In reply please quote: 22/25794

1 October 2024

SSD-50972718 – PROPOSED WALLGROVE ROAD BUSINESS HUB WITHIN WESTERN SYDNEY PARKLANDS AT 97-151 WALLGROVE ROAD, HORSLEY PARK (Lot 25 DP 2954 and Lot 24 DP 1152887)

Figure 7: Civil Engineering Site Plan, H&H 2025

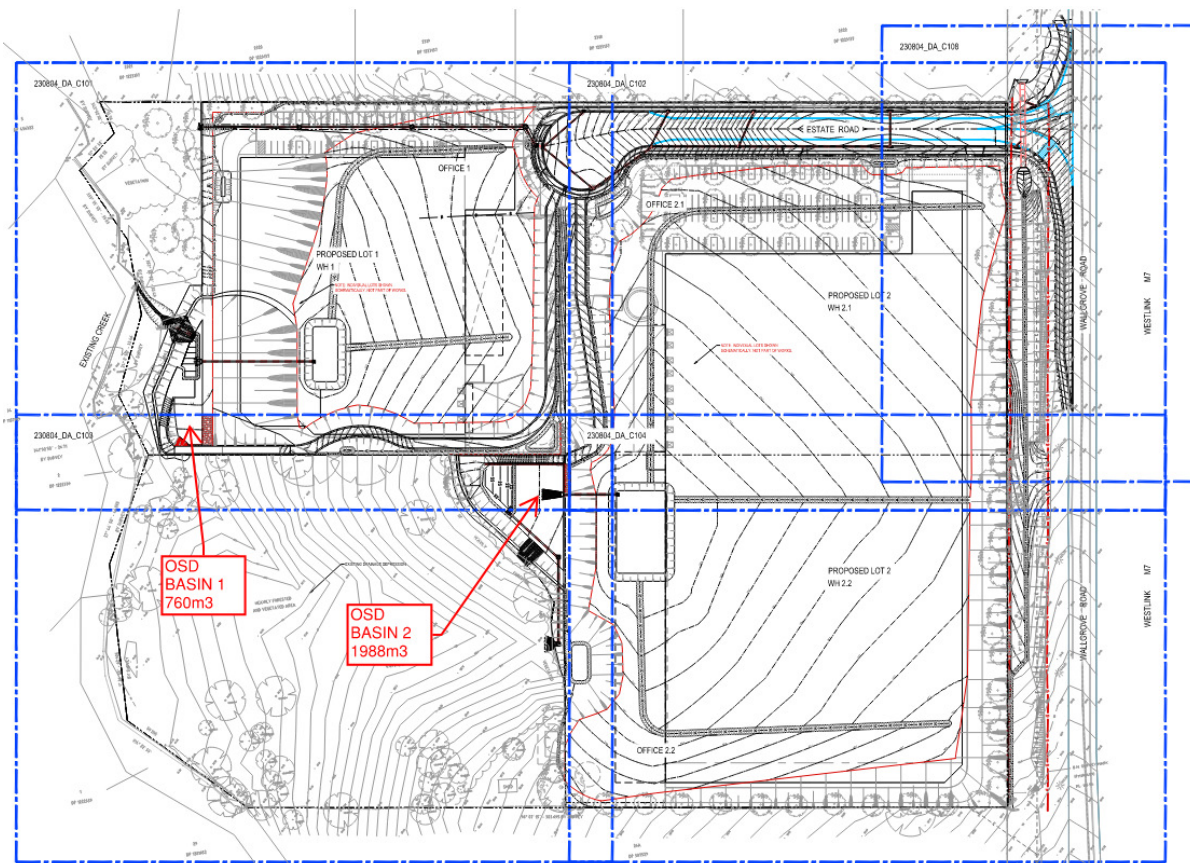
The discharge point from OSD basin 1 is considered too close to the creek. It is recommended that the discharge point be located further away from the creek to prevent erosion within the creek banks.
